# TR050007 Hinckley National Rail Freight Interchange

## Stoney Stanton Action Group

Comments on additional information supplied by TSH (10<sup>th</sup> Dec 2024) in response to the SoS's letter (10<sup>th</sup> Sep 2024)

5/2/2025

Existing Layout - Bus Utilising Stop in front of Co-op

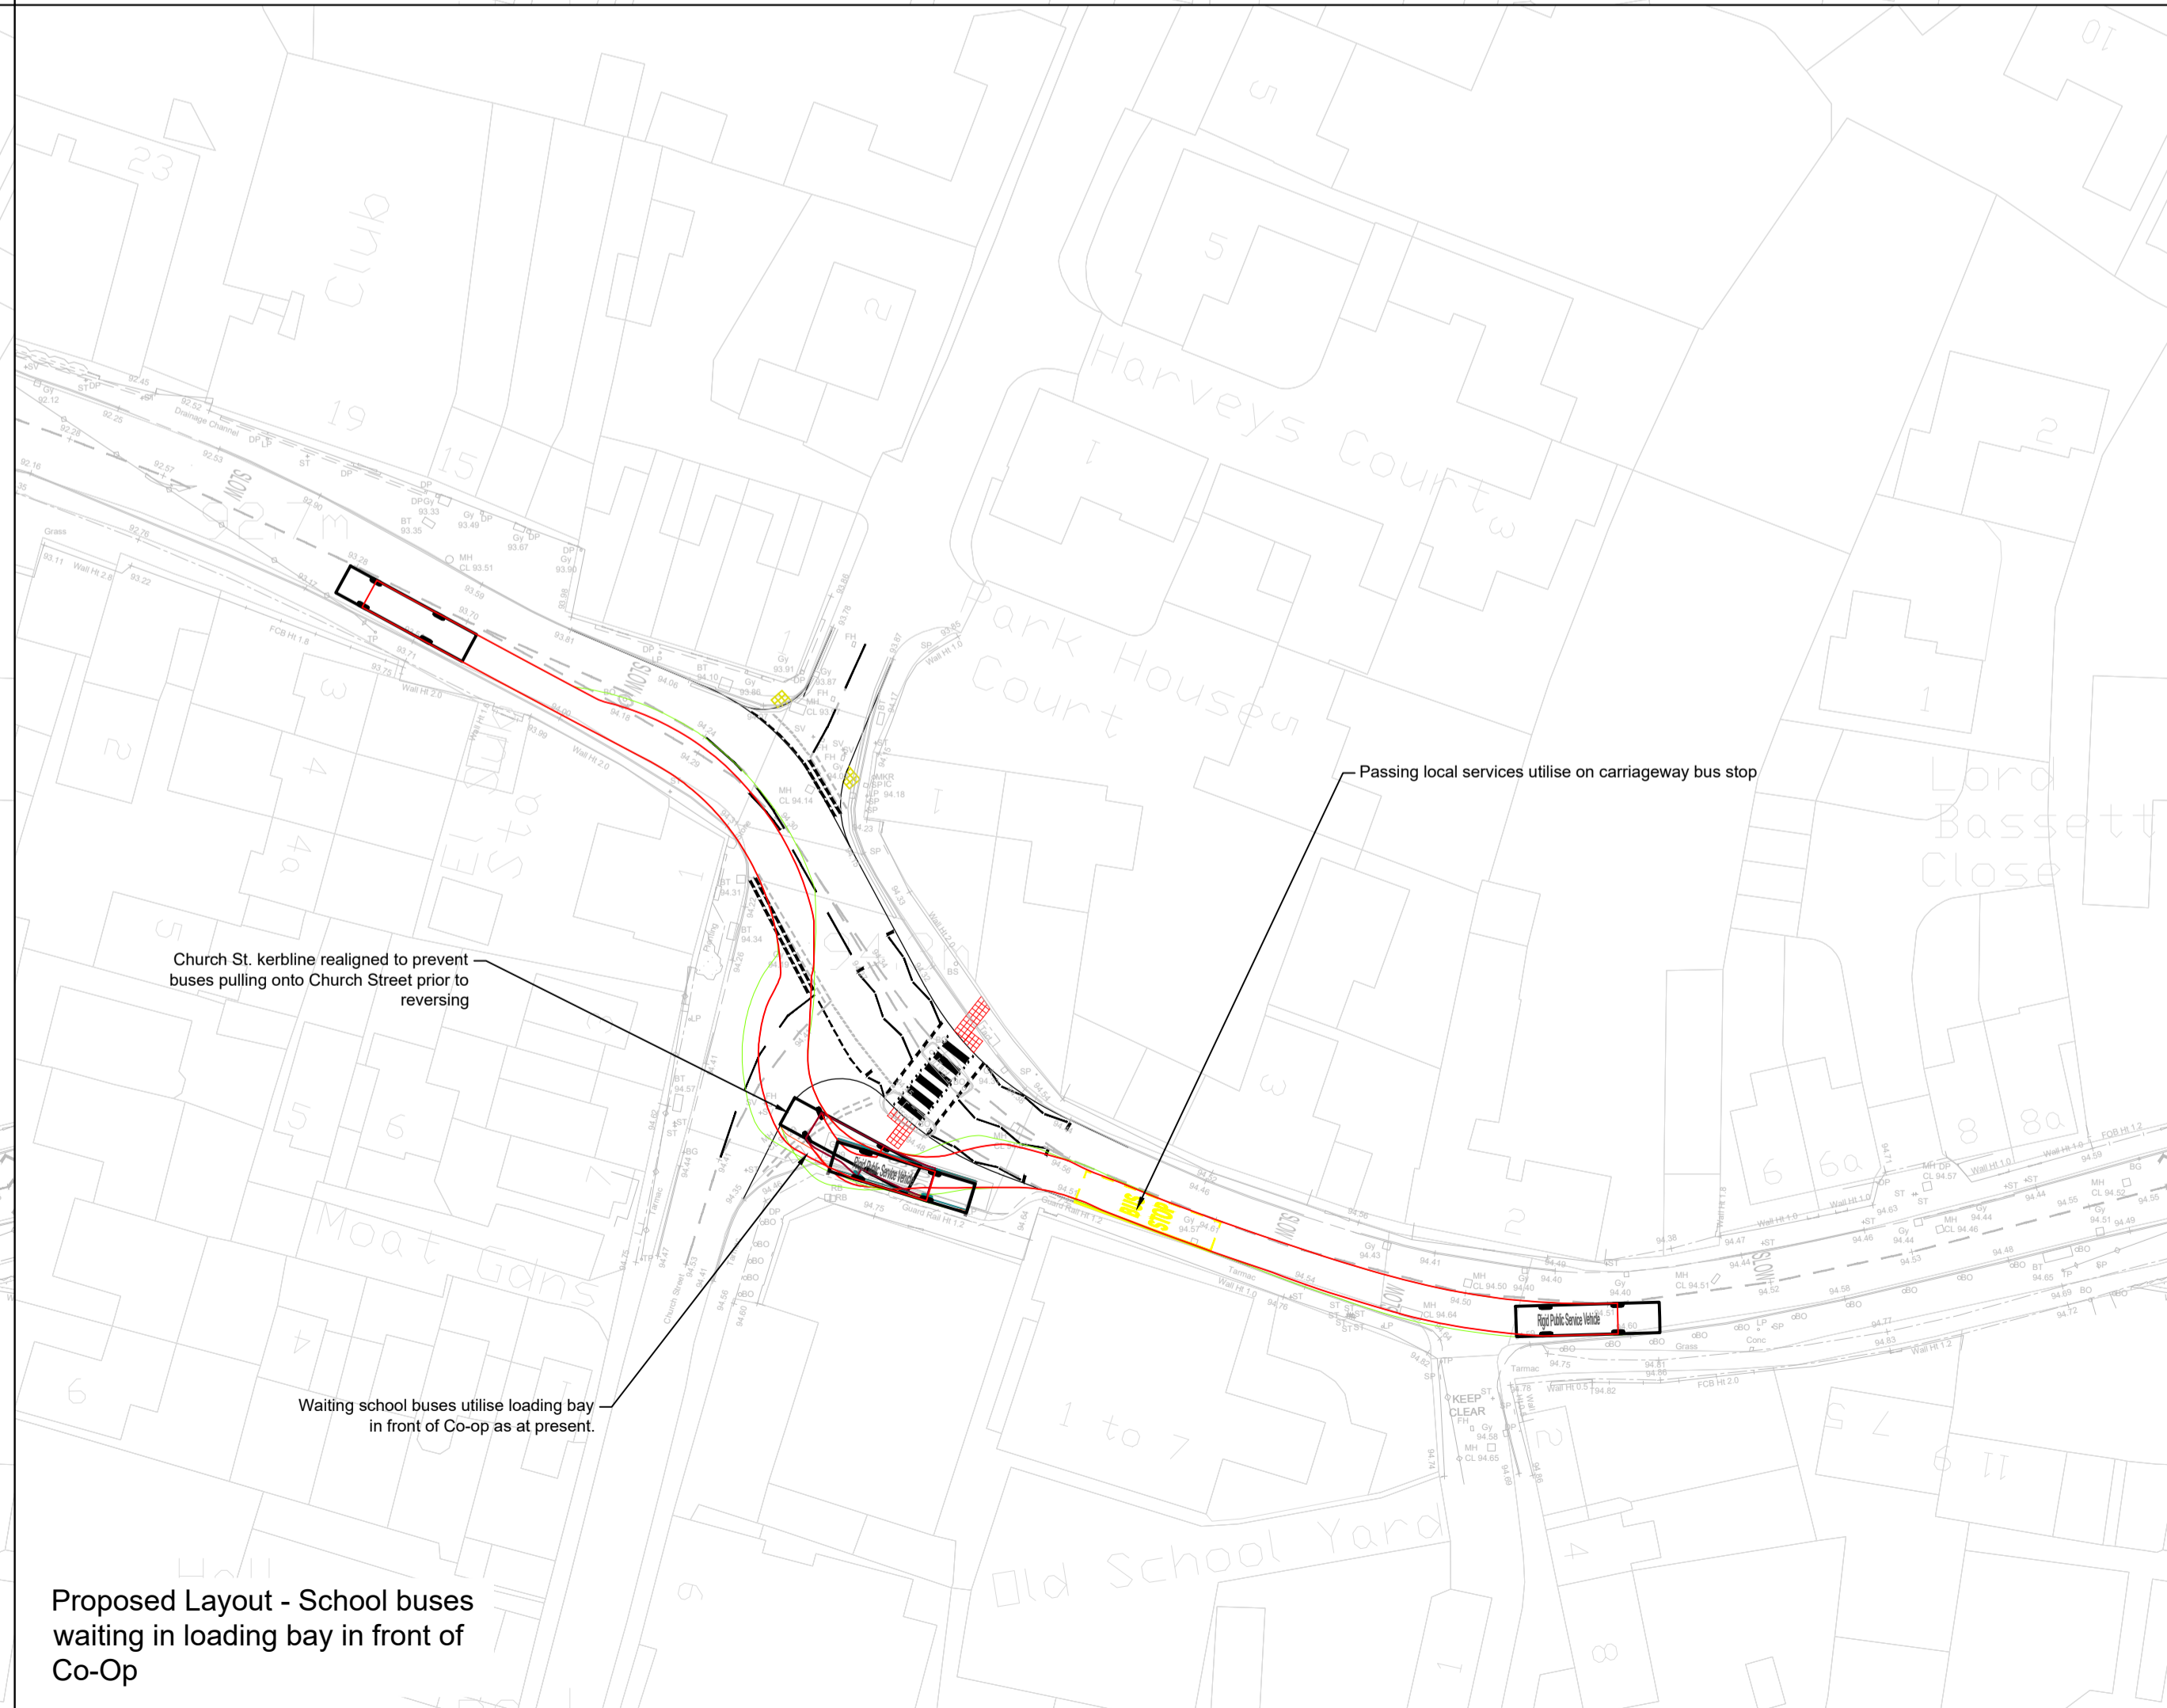
From a cursory read through "Appendix 2 - Sapcote Technical Note", another document that is overly dismissive of valid concerns. Table 2.1 in Section 2.12 of that document shows vehicle numbers for the B4669 to the West of the Co-op (Link 41) and to the East of the Co-op (Link 43). The HGV Annual Average Daily Traffic figures are inconsistent, for instance 2026 (scenario ii) Westbound is shown as 170 for Link 41 and 93 for Link 43. The difference is explained in section 2.13 by stating this shows that there is a significant proportion of local HGV traffic. From local knowledge it is easy to deduce that this is not likely, as all possible other destinations (e.g. Church Street and Stanton Road) are difficult to access by HGV. Additionally Westbound traffic for the Western Link (Link 41) increases by 10 in 2026 "with development", whereas the Westbound Traffic for Eastern Link (Link 43) increases by 1 in 2026 "with development". Either the HNRFI is creating additional local HGV traffic or the table is wrong. See photos in this document Section 4.

**WORK No.7 A47 LINK ROAD ACOUSTIC BARRIER SECTIONS GABION WALL OPTION**

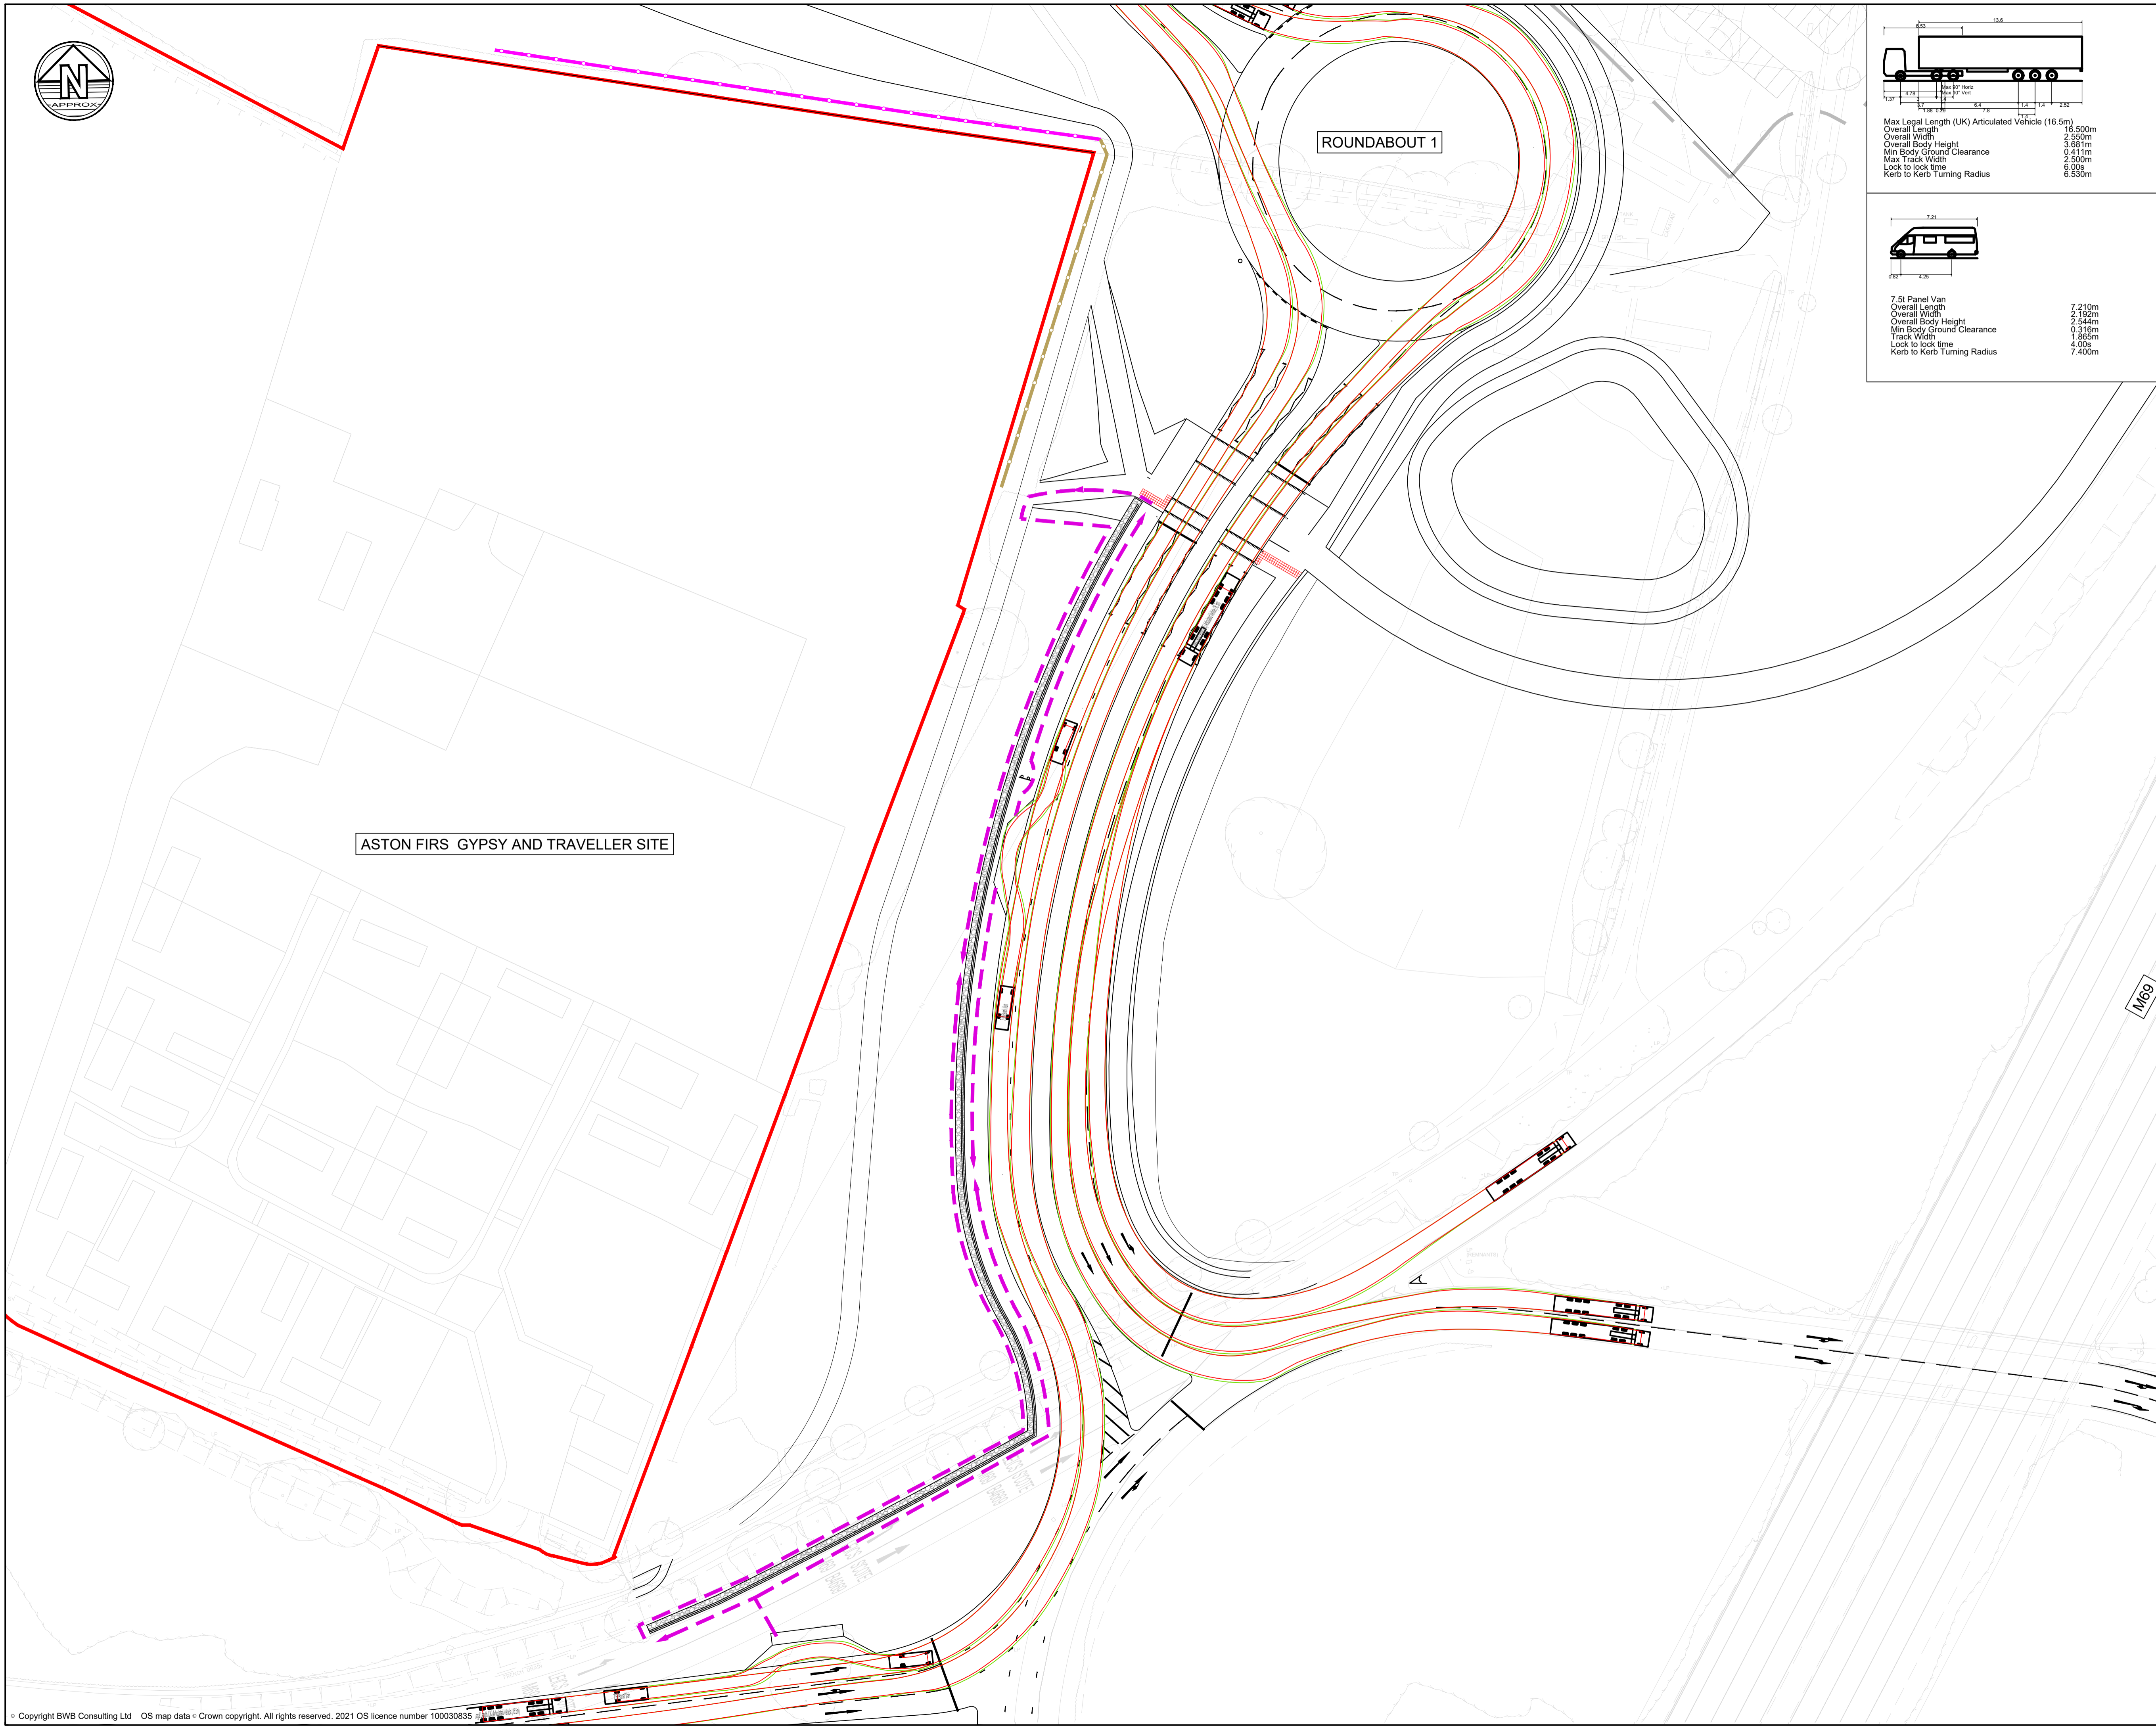
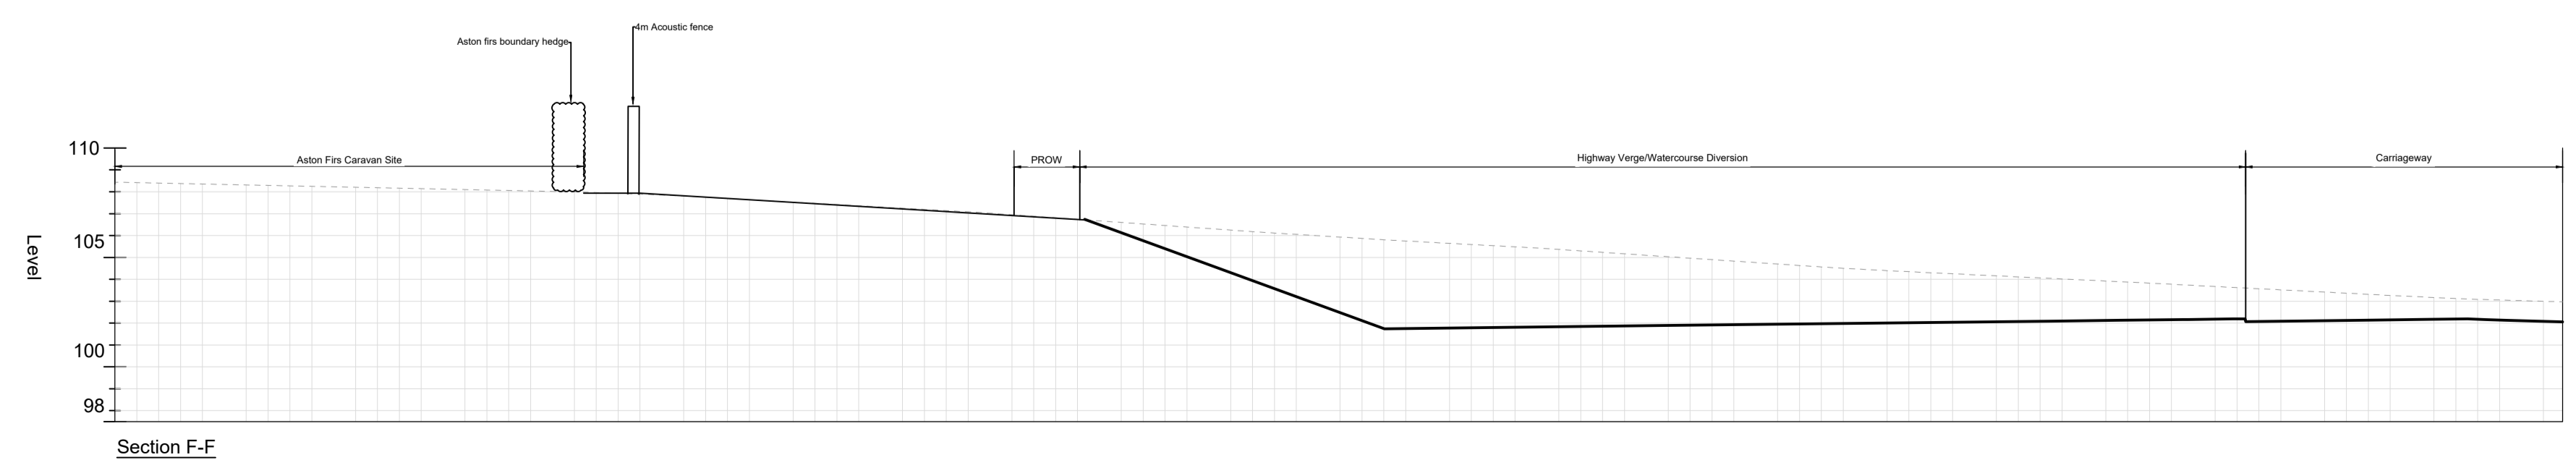
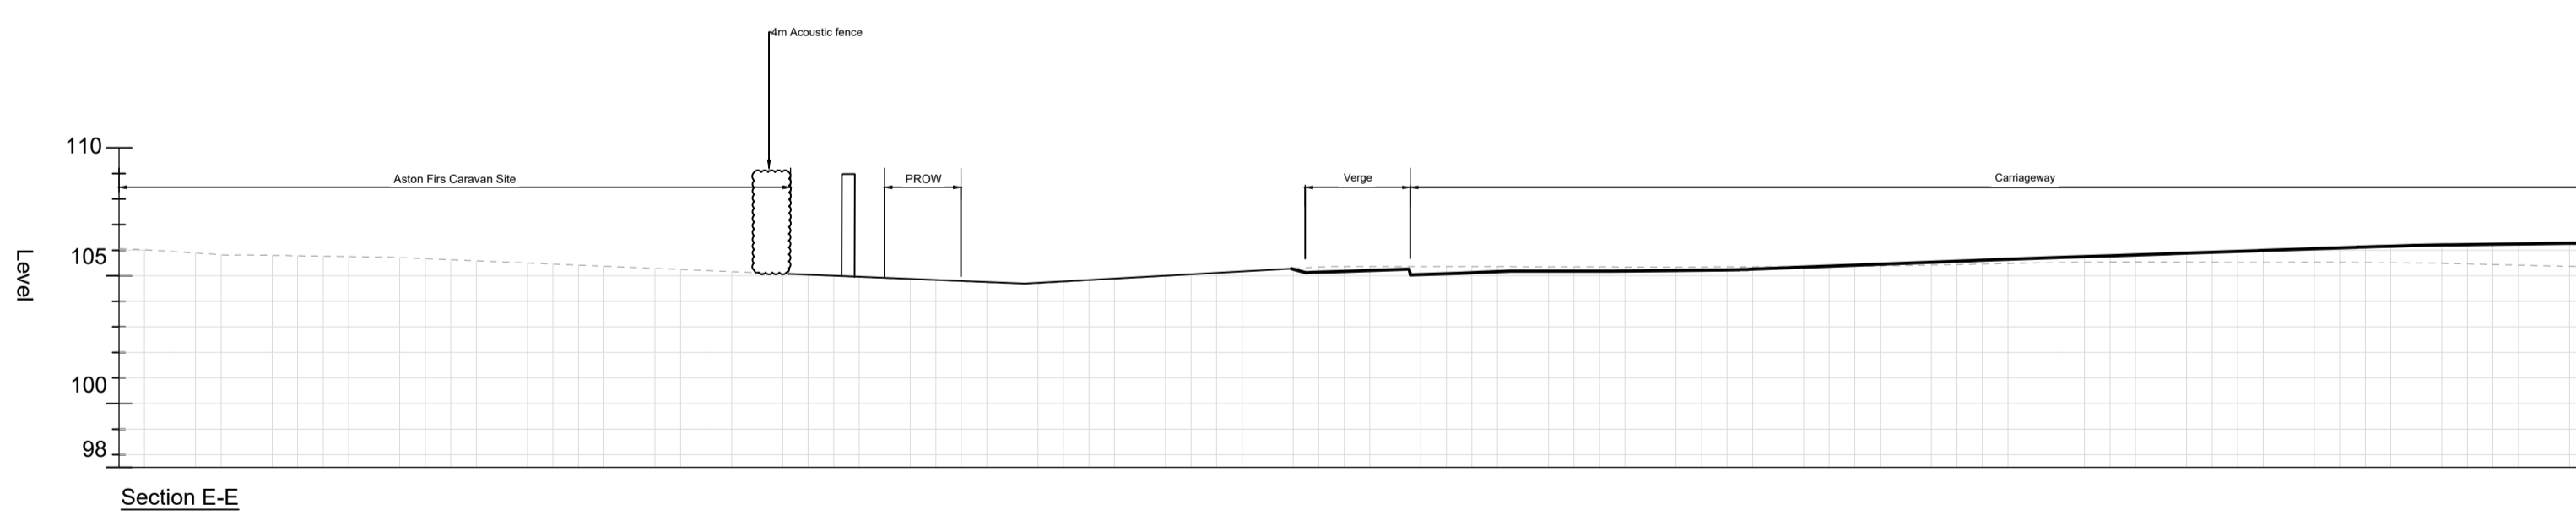
The Applicant responds to the Secretary of State’s concerns about the nature of the high acoustic barrier in TSH 2.37 to TSH 2.50. The statement in TSH 2.40: “The Applicant was surprised to read the ExA’s conclusions on this matter since it was an issue that received only limited attention during the examination itself. This matter had been subject to only a single written question during the Examination.” is deceptive. Most Interested Parties would not typically access this site, therefore would not be likely to raise questions based on their area of knowledge. The ExA did, quite rightly, arrange a site visit during the Examination, therefore it is our opinion that the ExA was able to come to an informed opinion and appropriately question the potentially harmful effects of the barriers (and indeed the whole problem of a major industrial site being constructed immediately adjacent to the traveller site).
